From: David Easton [REDACTED]
Sent: 17 January 2024 13:16
To: Rhett Flashman [REDACTED]
Cc: Silvie Steiningerova [REDACTED]; Sarah Fawdry [REDACTED]; Chris Brake [REDACTED]; Thomas Richards [REDACTED]
Subject: RE: Bilsham Road, Yapton - Y/70/22/DOC

Y/70/22/DOC – Condition 9 and 27

Application Ref: Y/70/22/DOC

Drawing Status	FOR APPROVAL		
Client	THAKEHAM		
Project	BILSHAM ROAD YAPTON		
Drawing Title	S104-CONSTRUCTION DETAILS SHEET 1 OF 2		
Scale	NTS	Date	FEB 22
Drawn By		Checked By	
Drawing No.	D1956-15-100		
Rev.	-

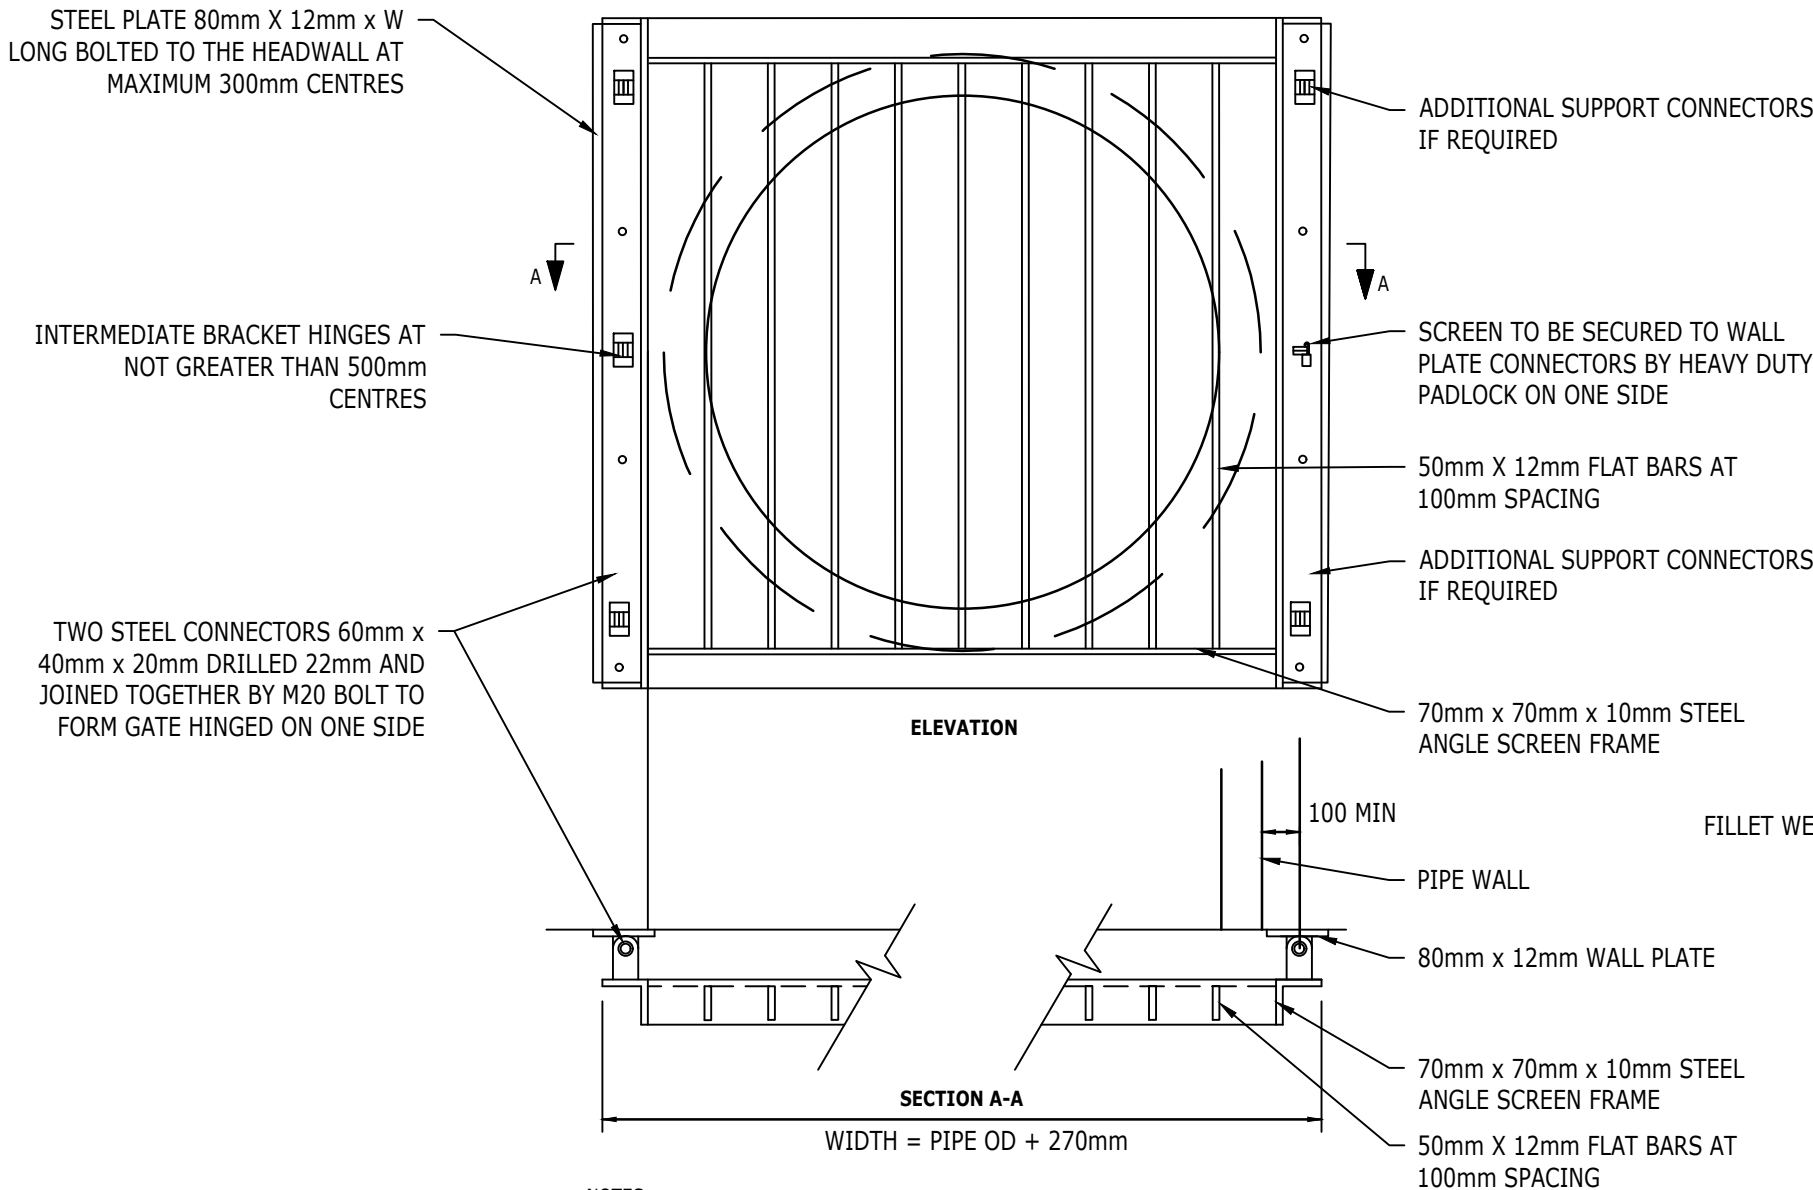
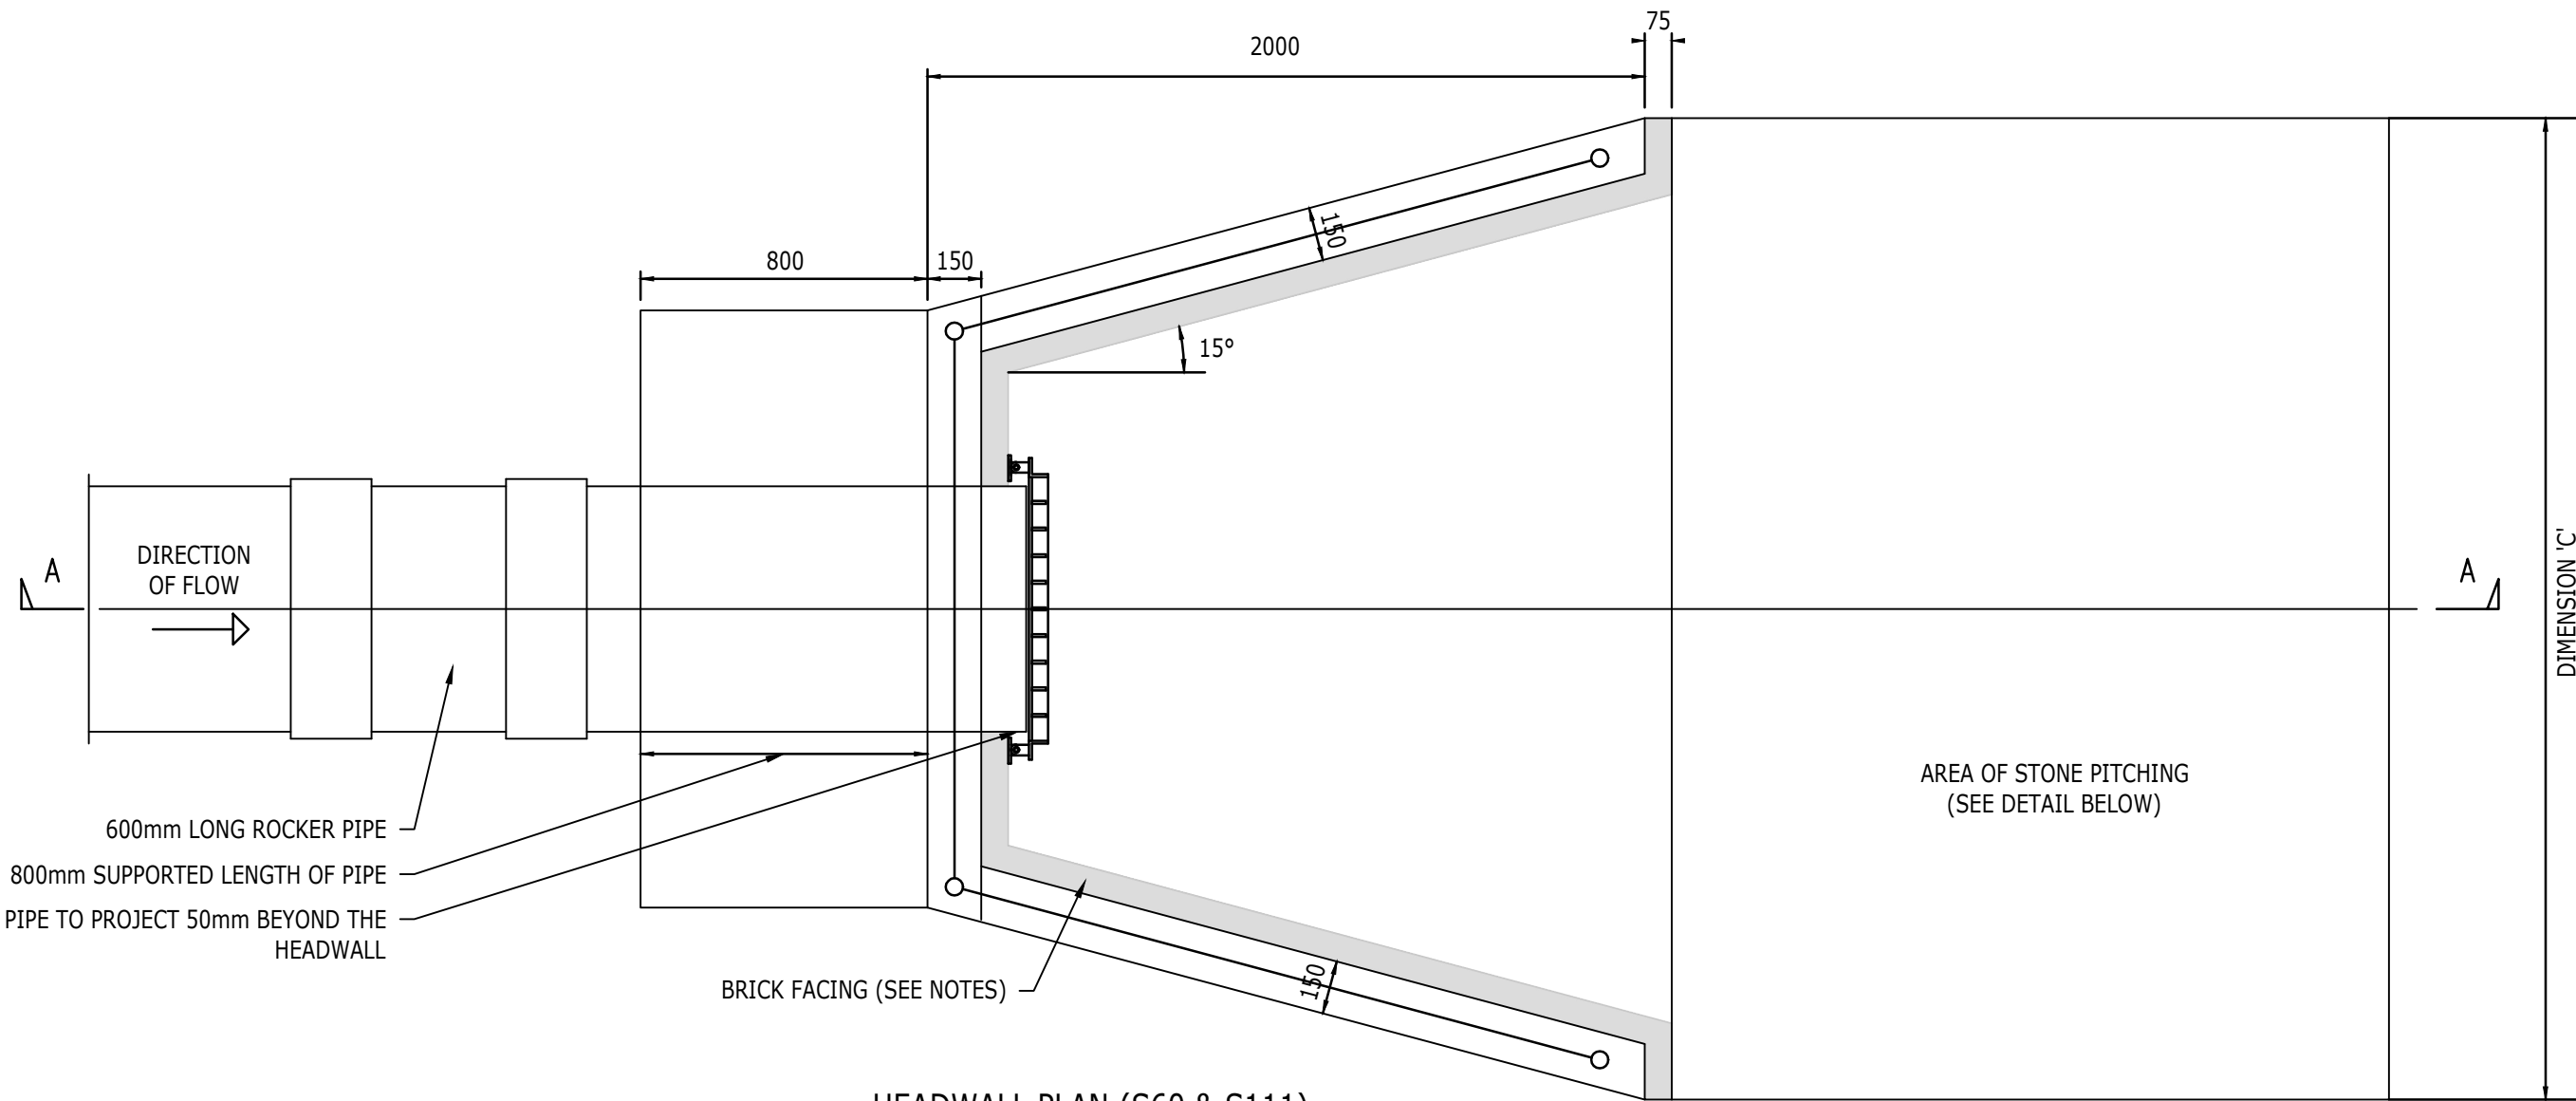
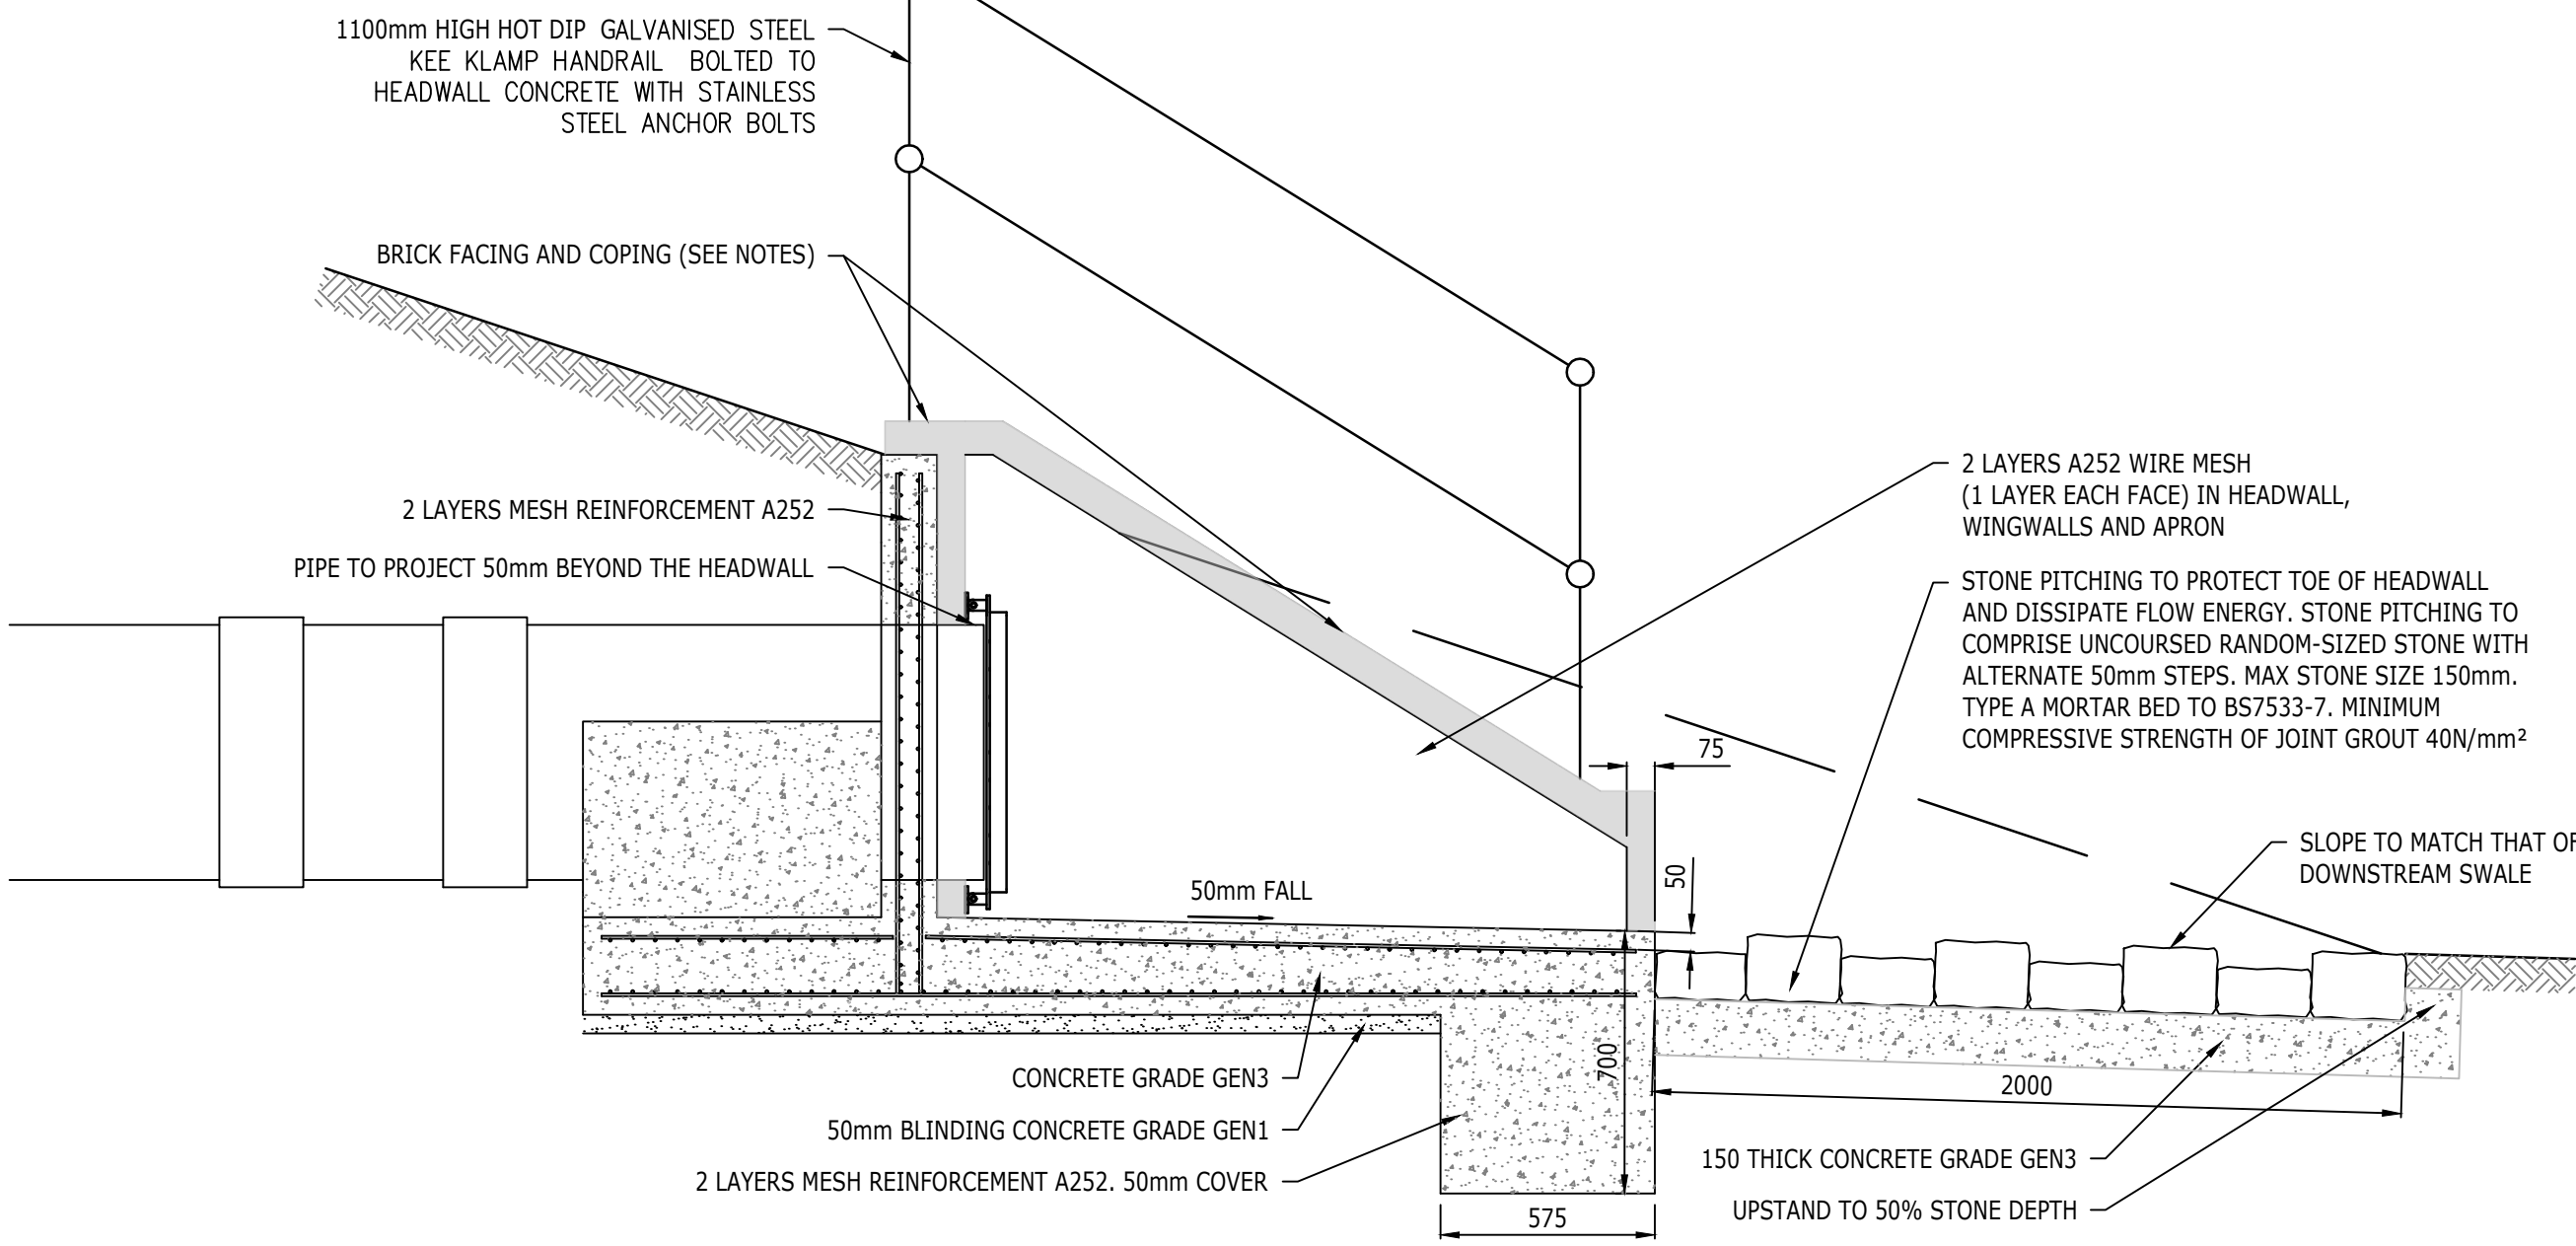
11. Please provide cranked grilles at a 45 degree angle. - Cranked grilles required on heads –S104 Construction details sheet 1 of 2 D1956-15-100 needs to be updated to suit ADC requirement. Pipe beddings details on this drawing are illegible in parts. Information needs to be clearly presented. We note that applicant's response that this is not "DSG compliant" however the drawings refer to Sewers for Adoption 7th Edition. As such the applicant needs to be clear which edition of Sewer for Adoption the adoptable drainage is being designed to. In addition they should confirm who the adopting authority will be as well as confirmation from the adopting authority on whether they will or will not accept cranked grilles. 08/02/2023- Whilst is noted that the Technical Approval certificate has been provided for information, this doesn't clarify whether the adopting authority has considered a request to use cranked grilles. This needs to be confirmed by the adopting authority otherwise cranked grilles should be used TH: There is no provision in DCG for the use of cranked grilles, only grilles installed flat against the headwall. In addition, we consider that cranked grilles create a health and safety issue as they could encourage people to climb up on them up to a perch from which people could fall
